Lime Down Solar Park

**Planning Inspectorate Reference:
EN010168**

**Wiltshire Council Comments on Submissions
Received at Deadline 2**

Deadline 3 (15 June 2026)

LIME DOWN SOLAR PARK
Figure 3-4-4.1
Lime Down Solar Park - Site D Sheet 1
Landscape and Ecology Mitigation Plan - Revision 4
END10168/APP/6.2
5(2)(a)

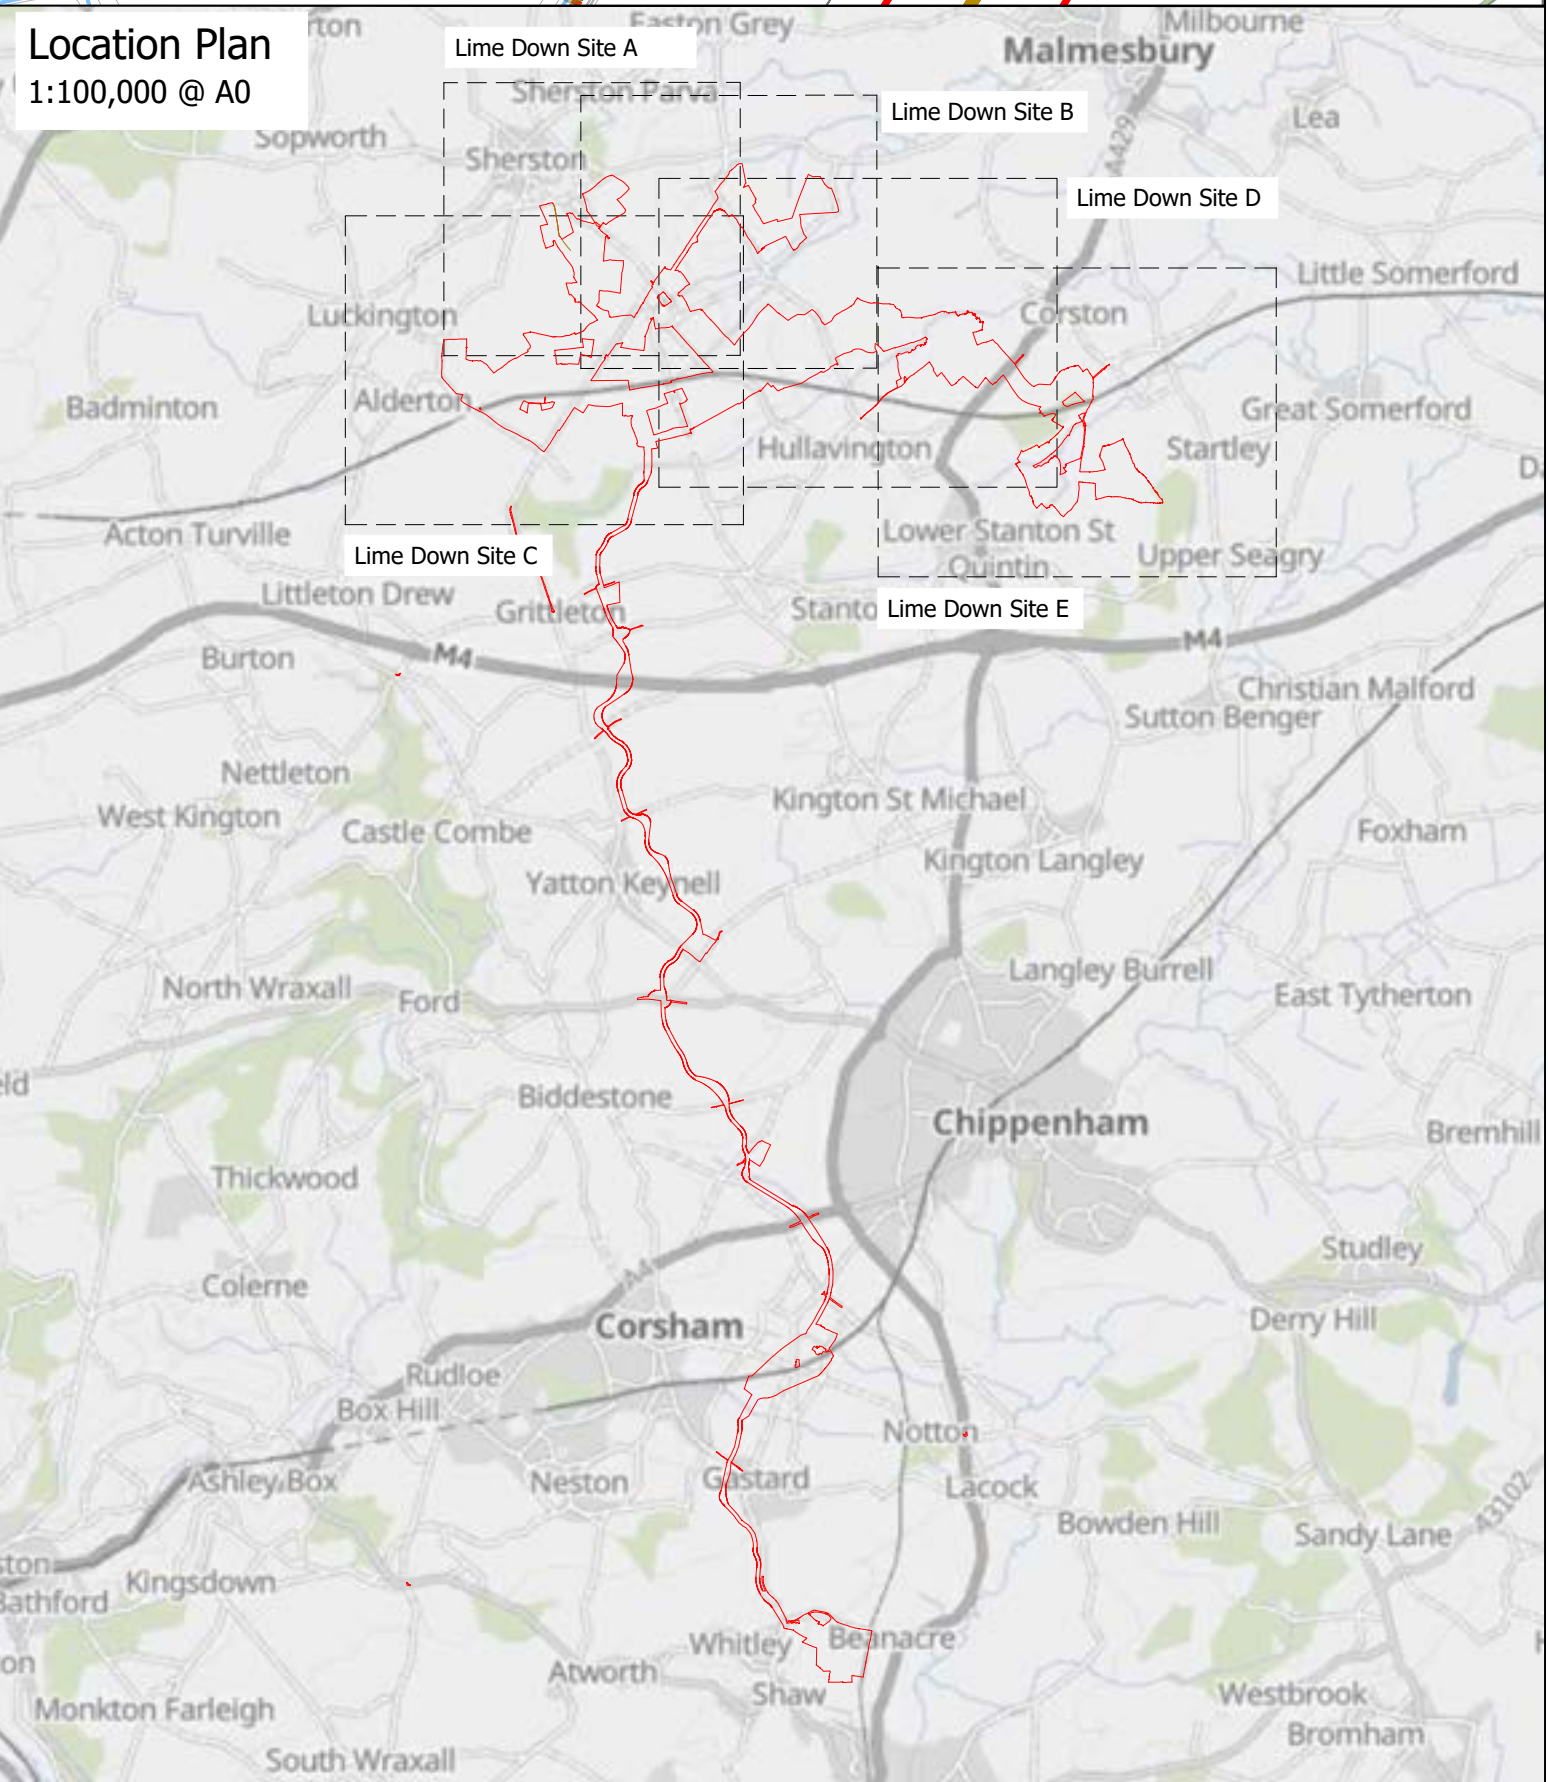
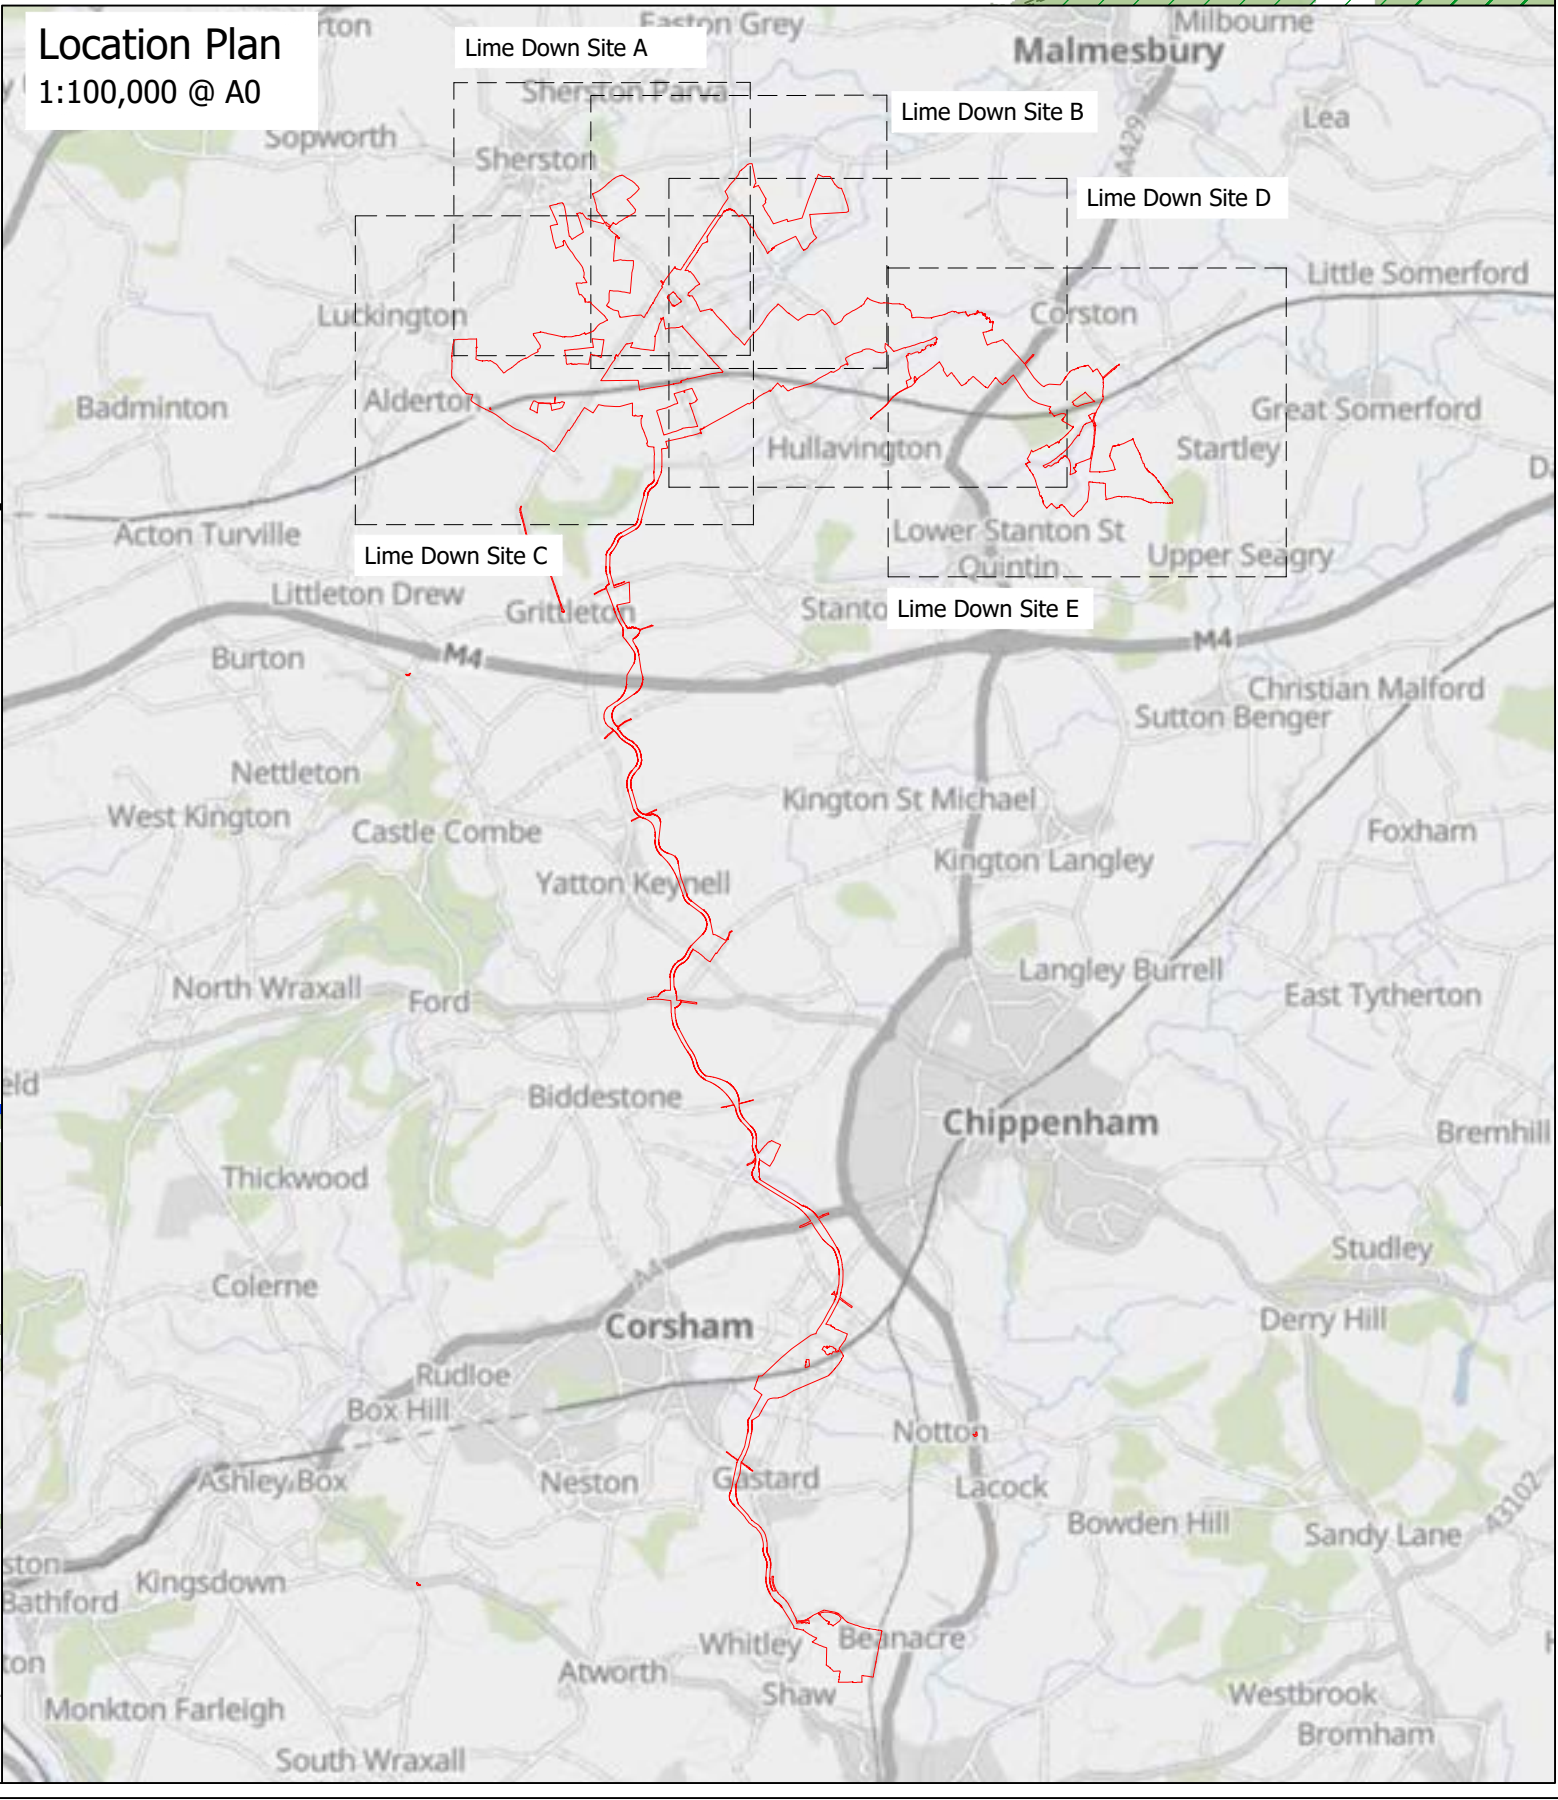
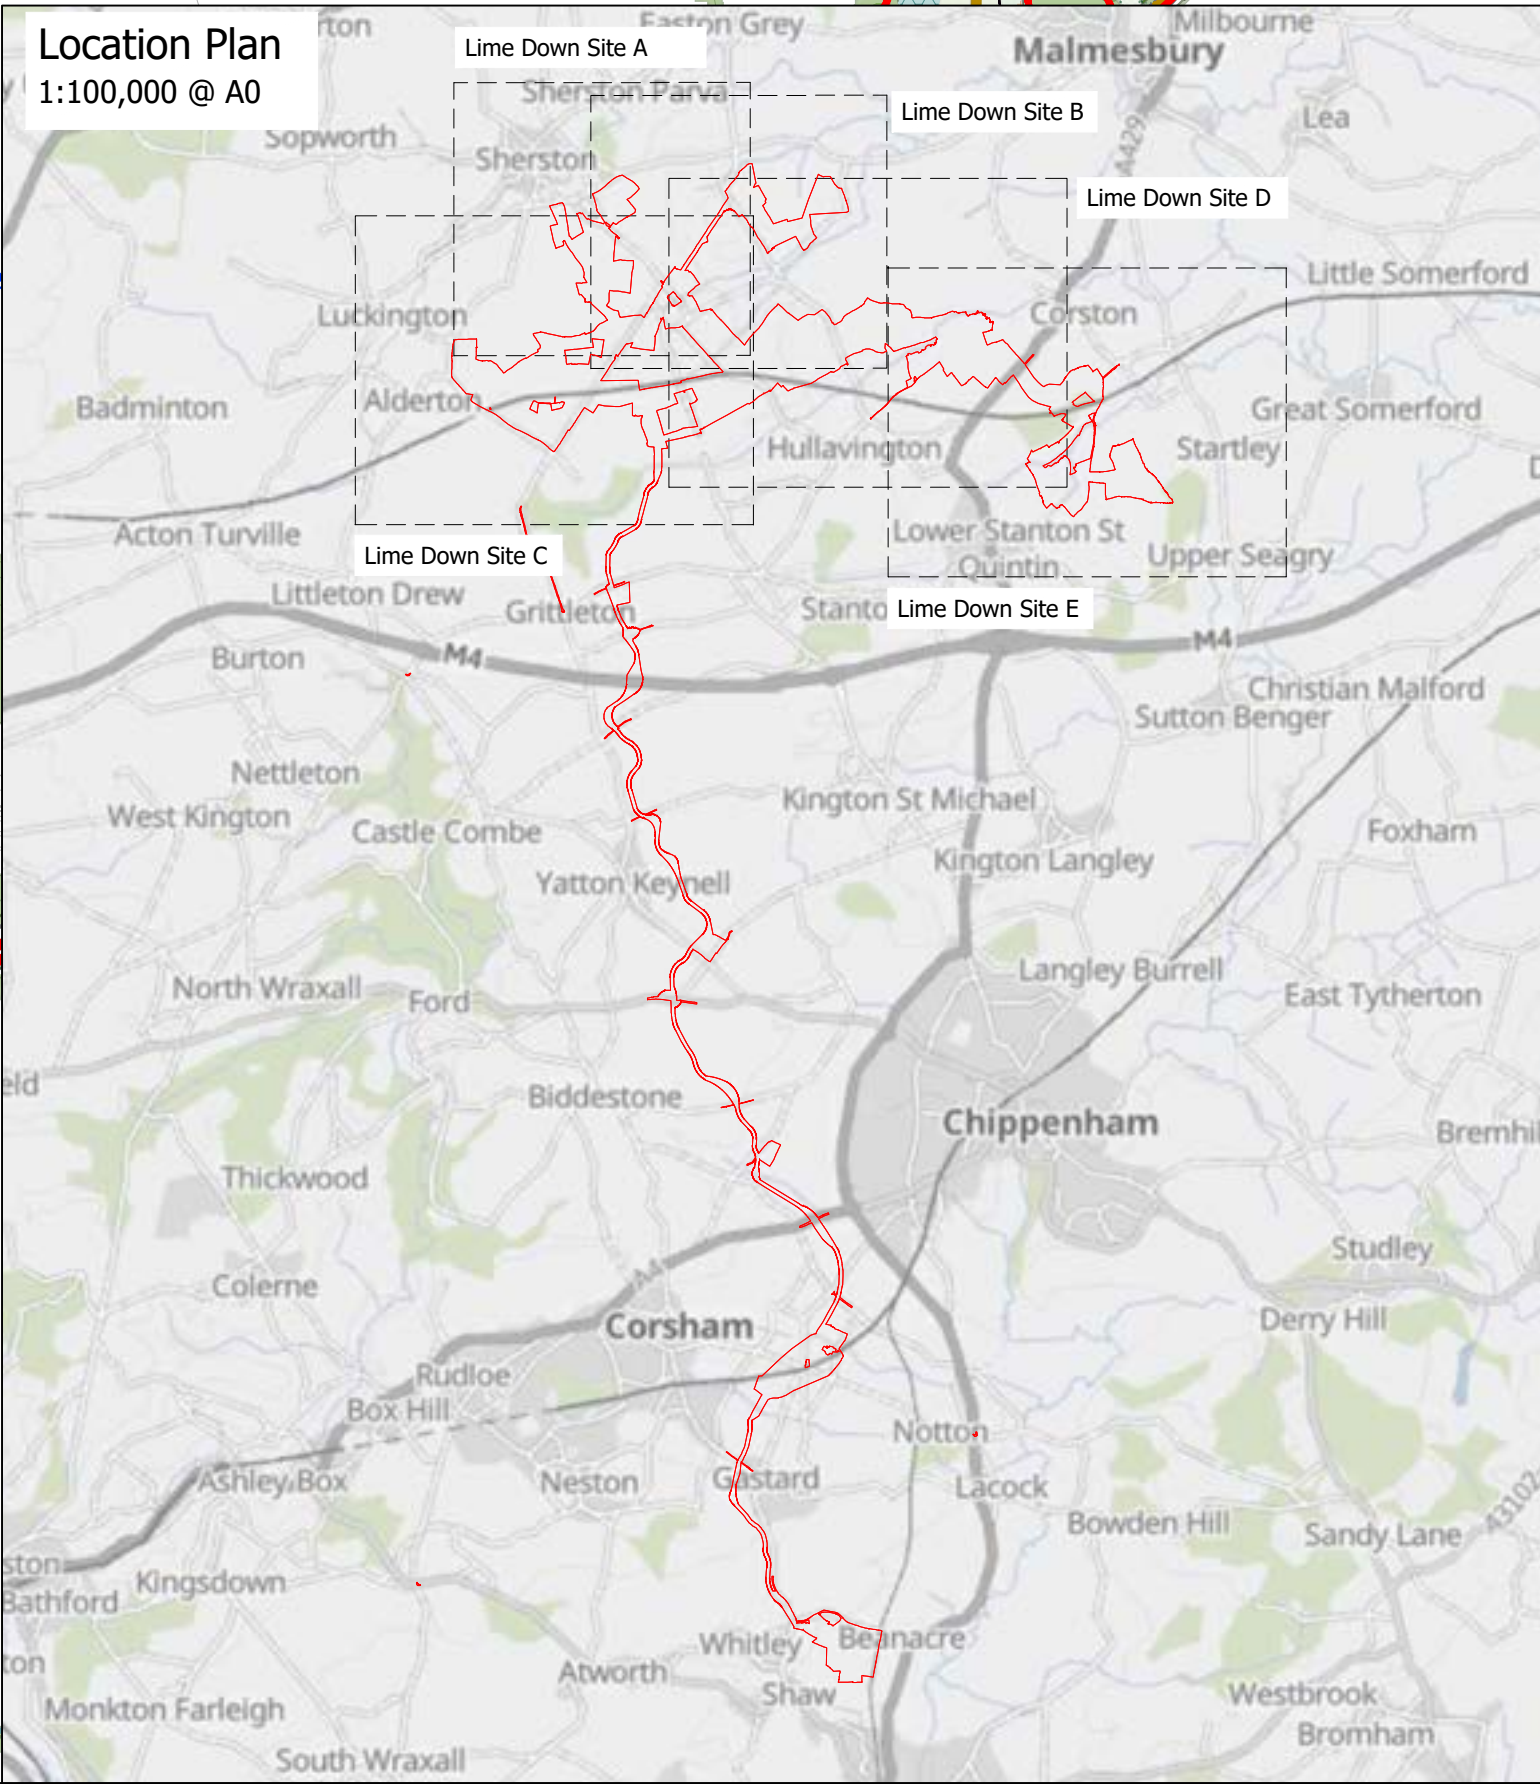
- 4.39. The Outline Landscape and Ecological Management Plan and ES Figure 3-4 must contain a table of species of tree, size, quantity and location to be provided for mitigated planting within the solar sites post completion of construction. The detail of mitigated planting for the removal of Category U and Category C trees must also be included within the design for replanting.
